WEST SUSSEX COUNTY COUNCIL CONSULTATION

TO:	Arun District Council FAO:Ms M Tomalova
FROM:	WSCC - Highways Authority
DATE:	21 January 2021
LOCATION:	Tyrone House Norton Lane Norton PO20 3NH
SUBJECT:	AL/2/21/DOC Approval of details reserved by condition imposed under ref AL/51/20/PL relating to Condition Nos 3 - materials & finishes, 5 - Energy Statement, 7 - car parking and 14 - external lighting
DATE OF SITE VISIT:	n/a
RECOMMENDATION:	Advice
S106 CONTRIBUTION TOTAL:	n/a

FIGURE 1 - PROPOSED PARKING

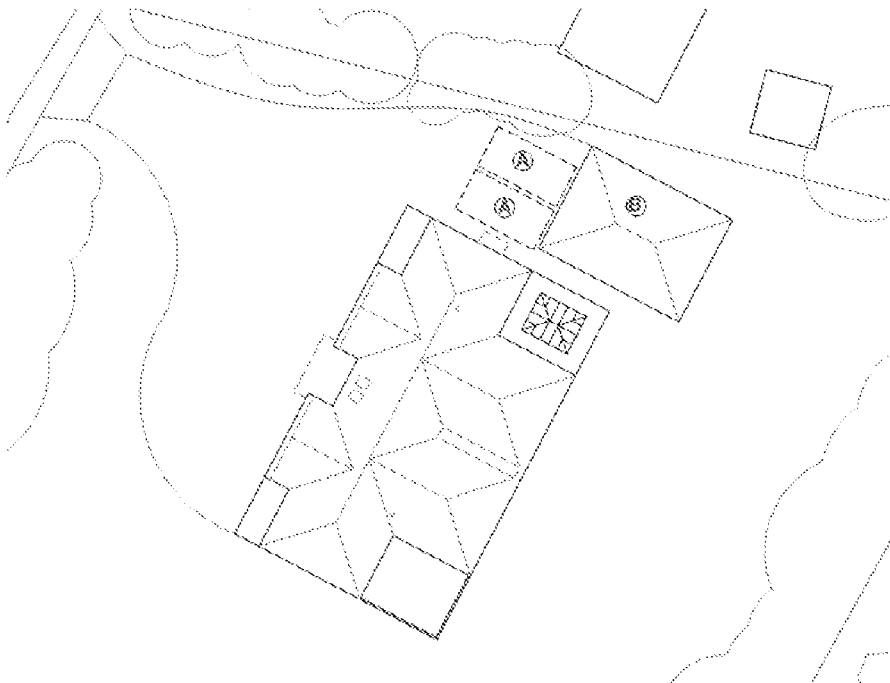
The supporting statement includes plan demonstrating a car parking for the proposed dwelling; however this has not been scaled. The proposed plan demonstrates 4 parking spaces, 2 within the proposed garage and 2 on the driveway. At planning stage, the proposed garage did not meet the requirements for a double garage. It is not clear if the internal size of the garage has been enlarged to accord with the current WSCC standards for double garage (6x 6m). Nevertheless, the site appears of sufficient size to accommodate the required onsite parking provision of 3 spaces.

The details submitted would be considered adequate to meet the requirement of condition 7.
